R/181/13/NMA

Application for a non-material amendment following a grant of planning permission.

Application for a non material amendment following a grant of planning permission R/90/13/ to omit the mansard to the front (east) elevation and raise the existing cavity wall, finishing it with tile hanging to provide a similiar appearance to original mansard.

FRONT (EAST) ELEVATION
STREET SCENE

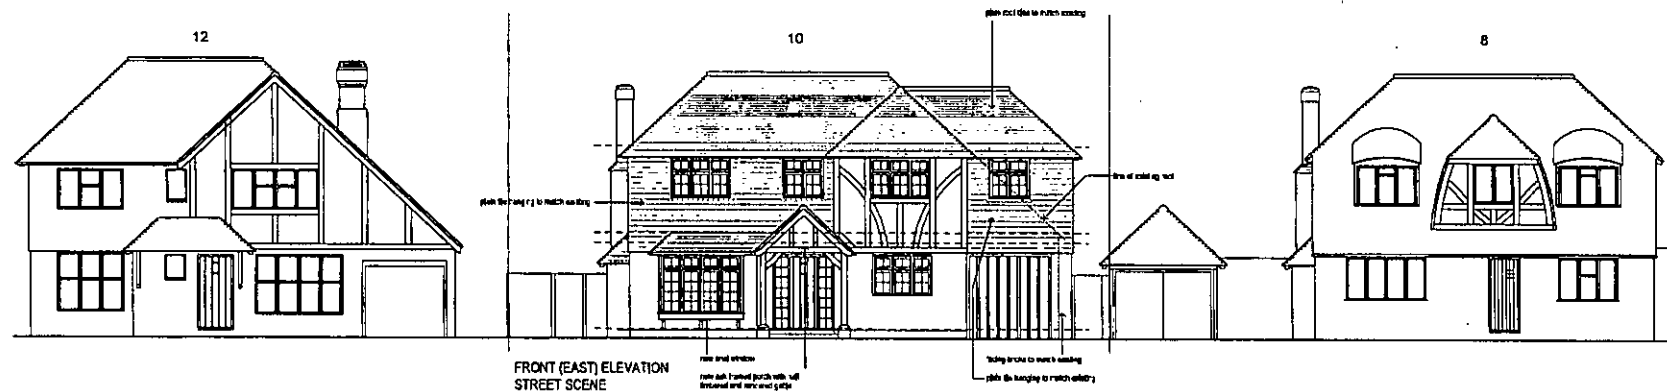
TO OMIT THE MANSARD TO THE FRONT (EAST) ELEVATION AND
RAISE THE EXISTING CAVITY WALL, FINISHING IT WITH TILE HANGING
TO PROVIDE A SIMILAR APPEARANCE TO THE ORIGINAL MANSARD.
NO INCREASE IN FLOOR AREA INVOLVED.

STRUCTURAL DIFFICULTIES IN RETAINING MANSARD FACE AND
DORMER WINDOWS TO THE FRONT (EAST) ELEVATION.
